File Ref. No: BFS17/2405 (8000001695)
TRIM Doc. No: D17/73118
Contact: Station Officer C. Wheatley

18 October 2017

**Comment on Proposed Development
Smeaton Grange Recycling Facility (SSD 7424)
52 Anderson Road Smeaton Grange**

drawing title  
GROUND FLOOR PLAN

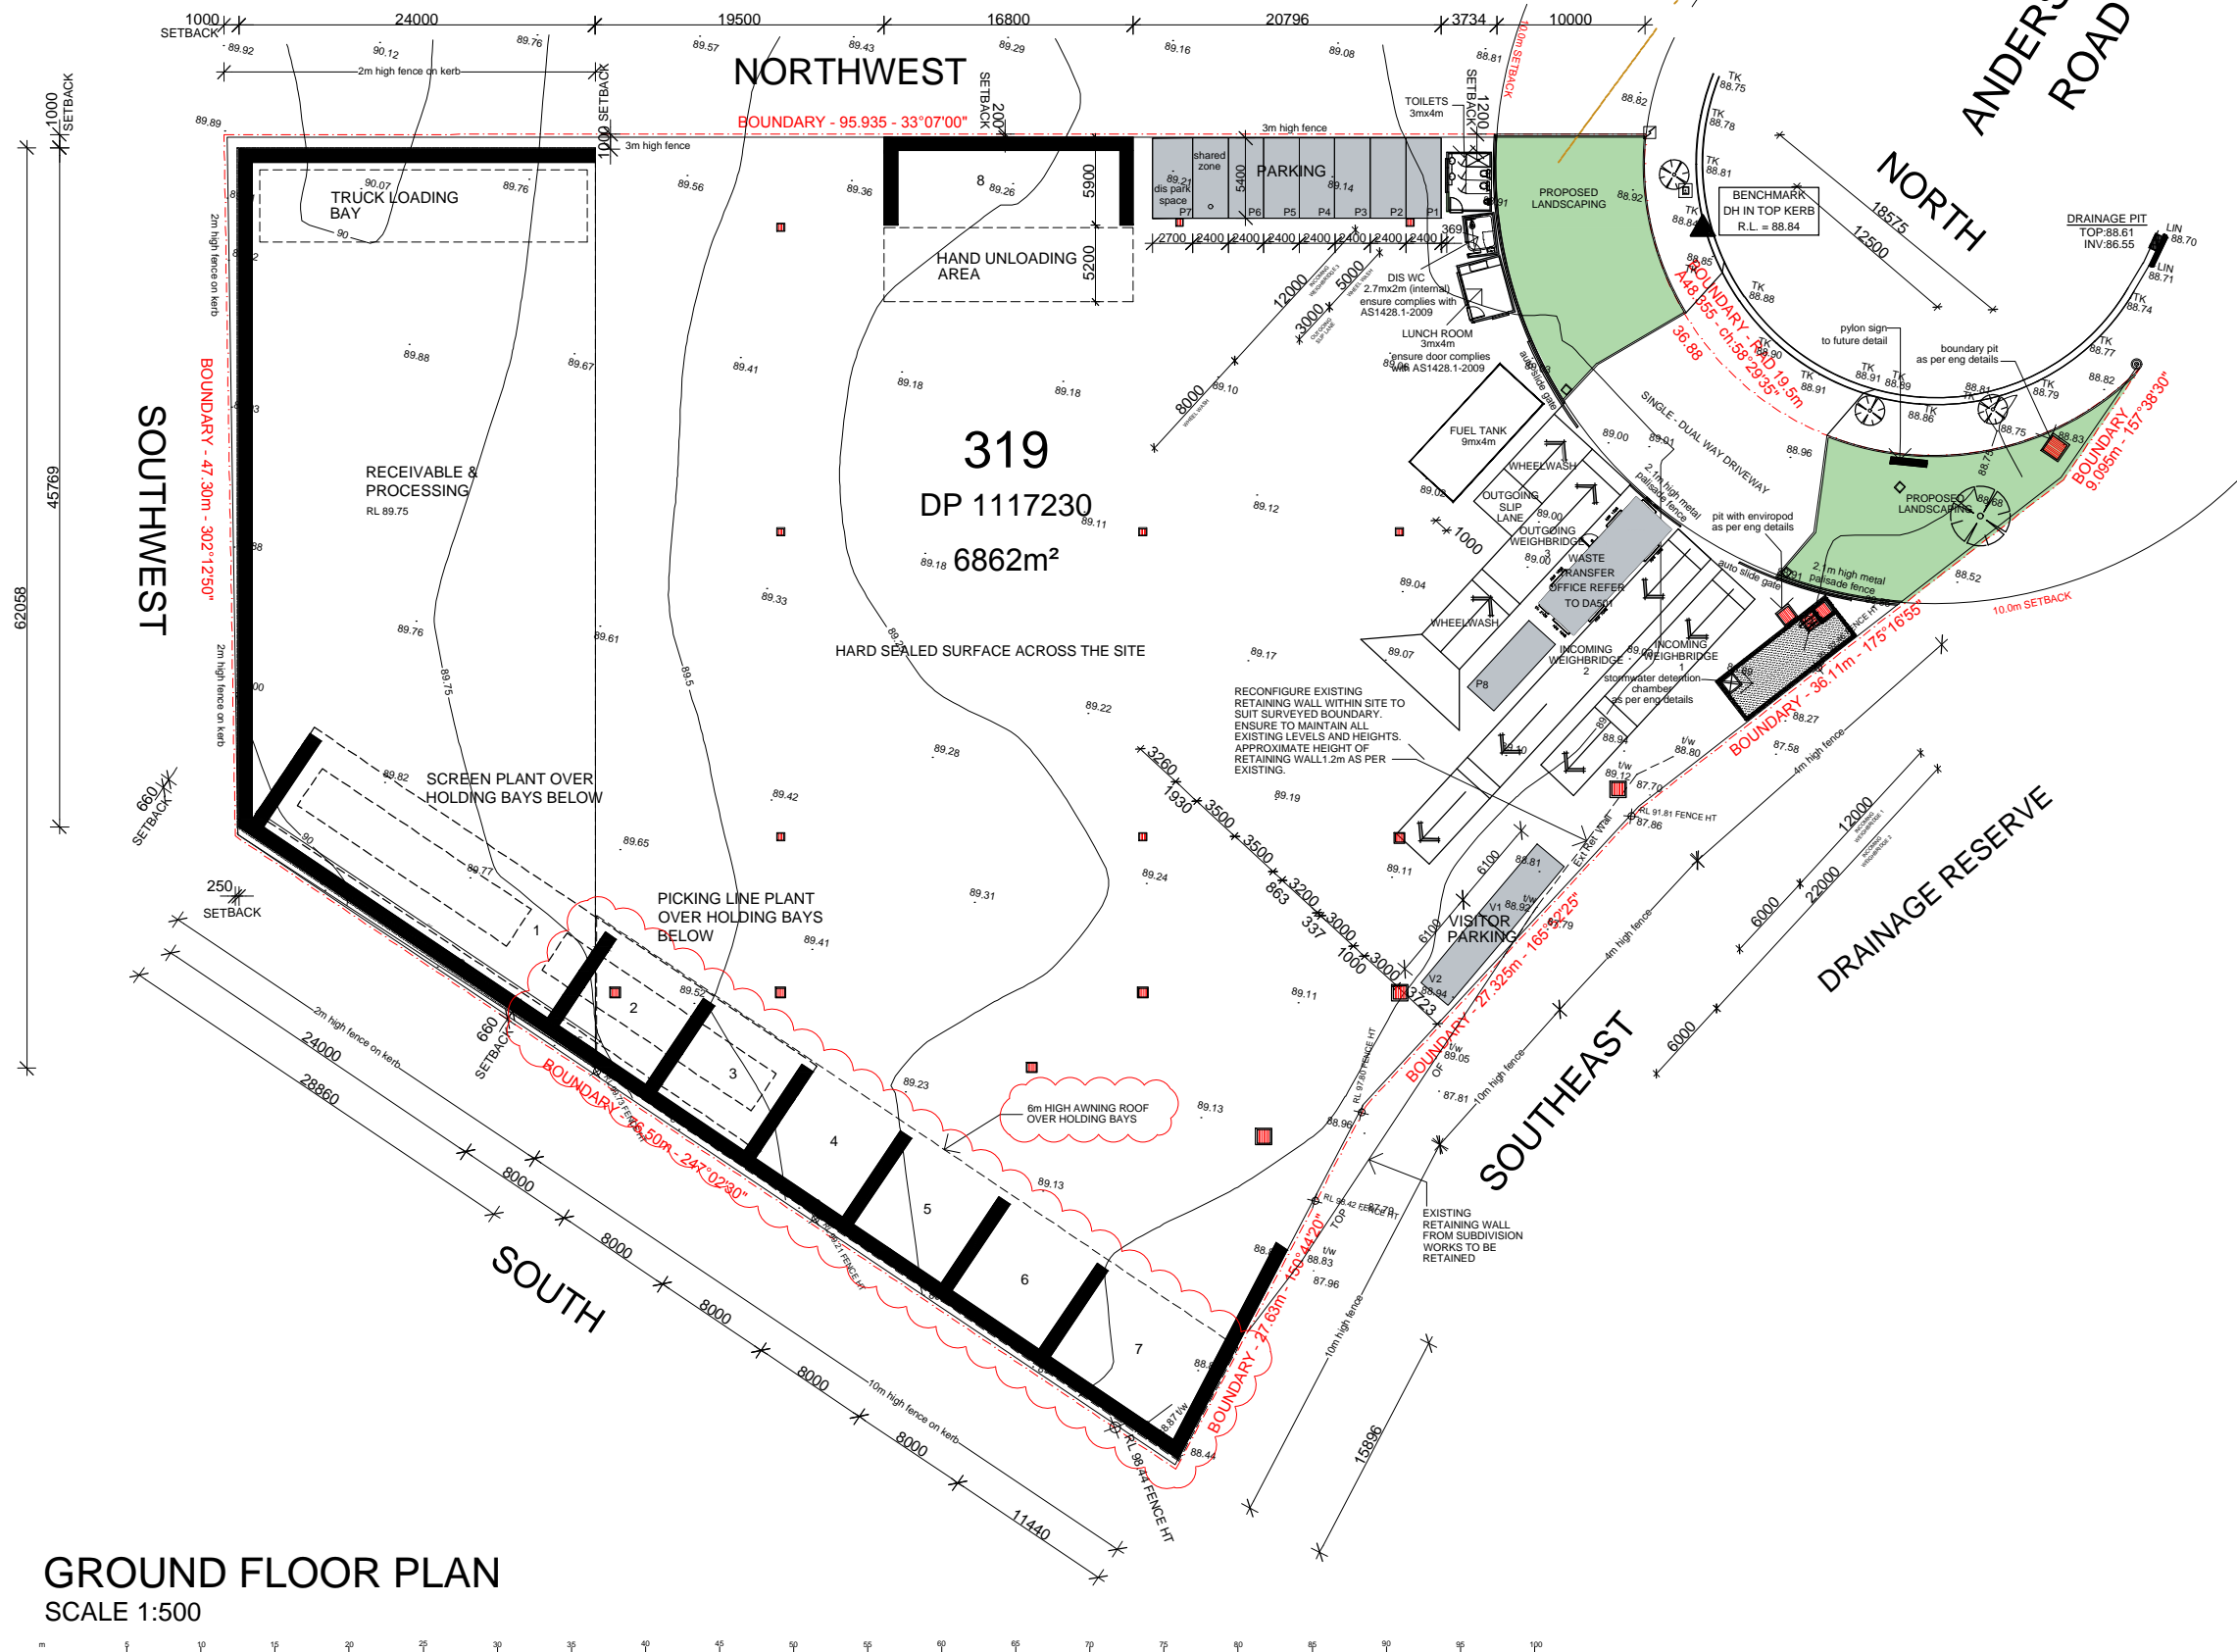
1. Based on the updated maximum stockpile quantities and site layout outlined within the above documentation, FRNSW recommends that the fire hydrant system for the proposed development is designed to provide a minimum fire water supply rate of 50 litres per second (L/s).

We acknowledge that our recommended minimum fire flow rate exceeds the maximum requirements of Table 2.1 of Australian Standard (AS) 2419.1 – 2005. Notwithstanding, in relation to a fire incident occurring at this particular development the provision of an on-site fire hydrant system, capable of delivering a minimum fire flow of 50 L/s, will enable FRNSW personnel to safely and efficiently manage a fire emergency through to incident resolution.

To successfully implement the necessary fire ground tactics, FRNSW personnel would need to deploy numerous hose lines – hence the recommended minimum fire flow rate of 50 L/s.
